Item No. **Report of the Head of Planning, Transportation and Regeneration**

Address 128D & 130D MANOR WAY RUISLIP

Development: Raising of roof to add 2 x studio flats, ground floor infill extension, single storey front extension and conversion of 2 x 1-bedroom flats into 2 x studio flats

LBH Ref Nos: **73728/APP/2021/3884**

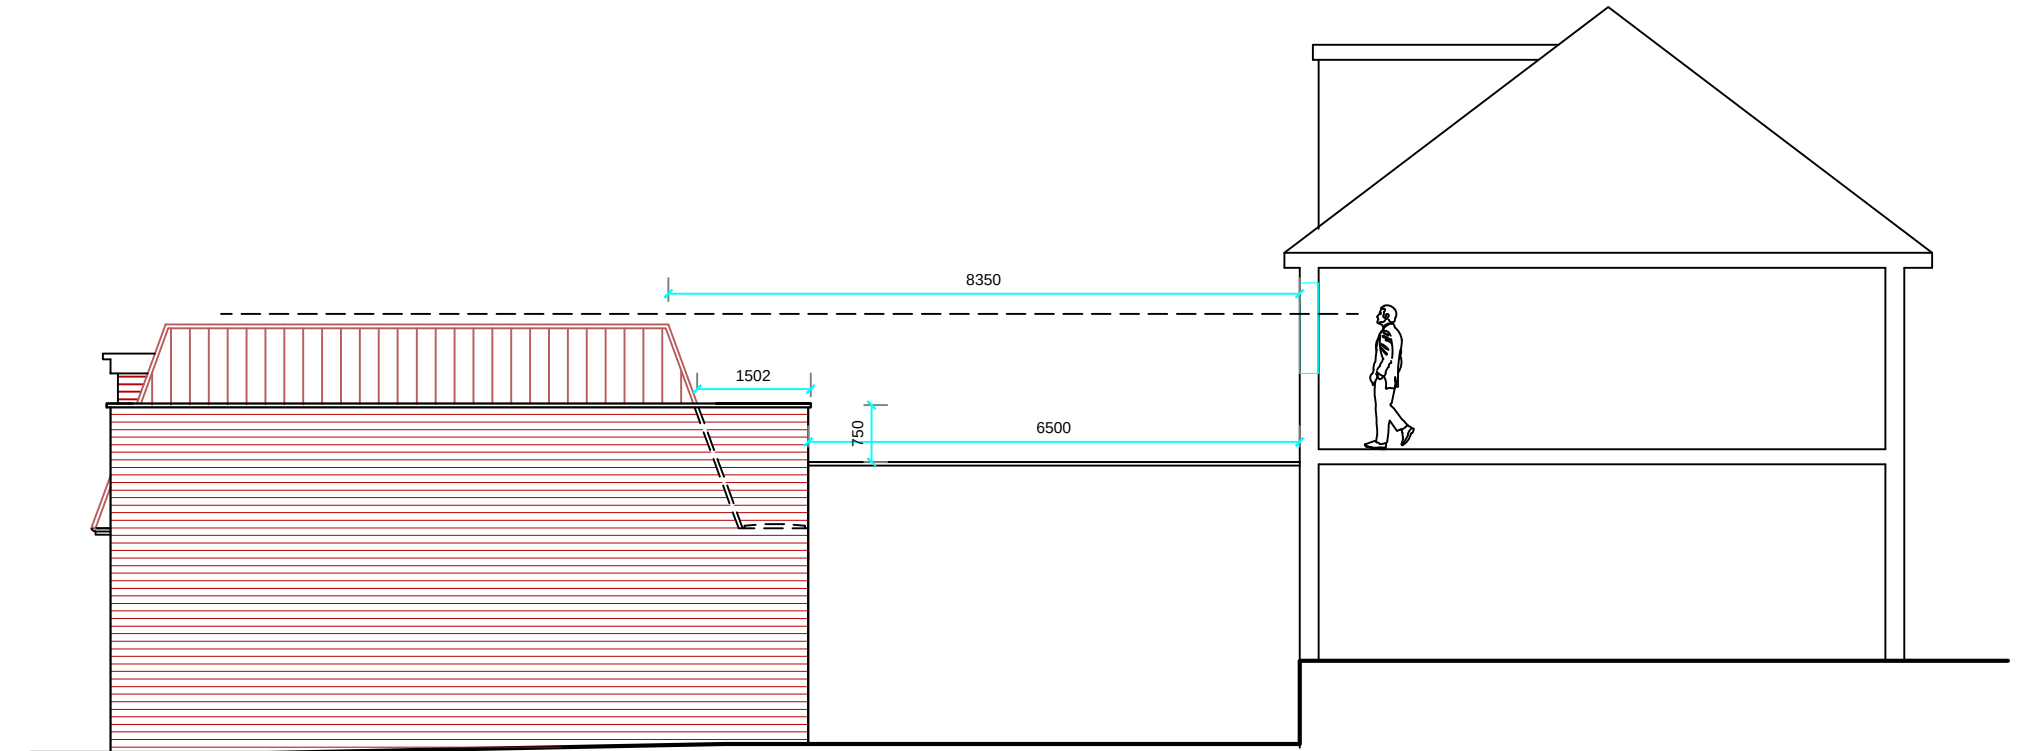
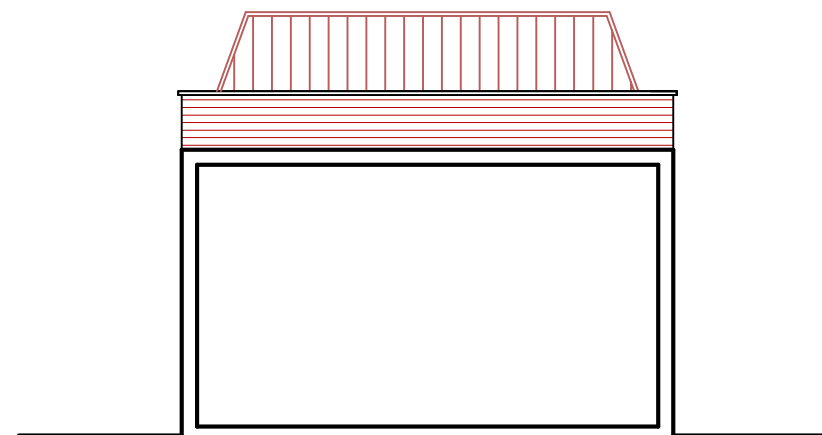
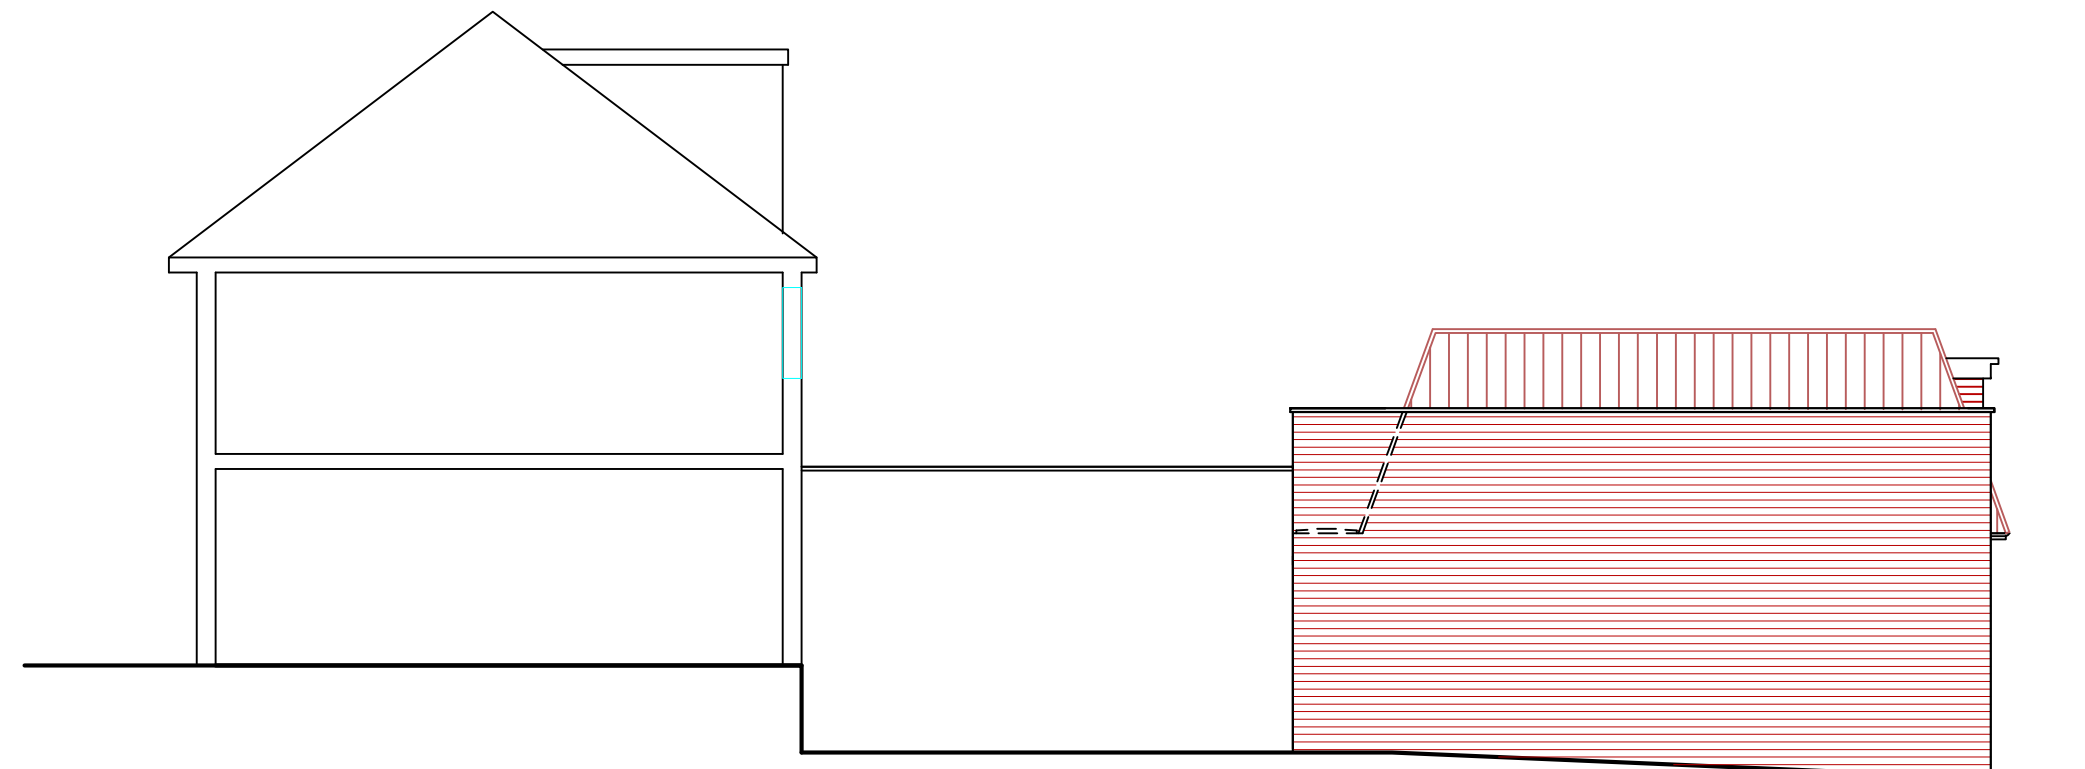
The proposed development, by virtue of the position of the front habitable windows and Juliet balcony of Flats 2 and 4 and their close proximity to the blank facade side wall at number 42 Windmill Hill, would result in poor outlook, overbearing impact and an oppressive living environment for the future occupants of these flats. The proposal would therefore result in substandard forms of residential accommodation to the detriment of the amenity of future occupants of the proposed development, contrary to Policy DMHB

The proposed development, by virtue of the position of the front habitable windows serving Flats 1 and 2 in relation to the existing service road and proposed cycle/refuse stores together with the proposed demolition of the existing boundary wall, would result in poor outlook, a loss of privacy and unacceptable noise and disturbance for the future occupants of these flats. The proposal would therefore result in substandard forms of residential accommodation to the detriment of the amenity of future occupants of the proposed development, contrary to Policies DMHB 15 and DMHB 16 of the Hillingdon Local Plan: Part Two - Development Management Policies (2020), Policy D6 of the London Plan (2021) and the National Planning Policy Framework (2021).

Notwithstanding the introduction of the proposed oriel bay windows, the primary views for the ground floor Flat 2, would be of the unrelieved and extensive side wall of No. 42 Windmill Hill. The proposed oriel bay window design of Flat 2 would not mitigate its close

proximity to No.42. This constrained and poor relationship would result in the flank wall of No. 42 being a dominant and overbearing feature, which would materially harm the quality of the outlook for the occupiers of the ground floor Flat 2. For the same reasons, the future occupiers of the upper floor Flat 4 would be afforded with an unacceptably poor level of outlook. This is despite of the proposed angled Juliet balcony and articulation to the upper rear of No. 42 (as identified by the Inspector of the above Appeal Decision).

The proposed removal of the boundary wall means that there would be no defensible space between the oriel bay windows of the ground floor flats and the adjoining service road, positioned only 3.8 metres away. Consequently, users of the private service road would be able to directly look into the ground floor Flats 1 and 2, which would result in a loss of privacy. Furthermore, the oriel bay windows serving Flats 1 and 2 would face directly towards the bin and cycle store, which further compromises the level of outlook afforded to future occupiers. The ground floor flats would be more susceptible to noise and disturbance associated with the private service road due to the proposed increase in depth, the position of the oriel bay window and the removal of the boundary wall.
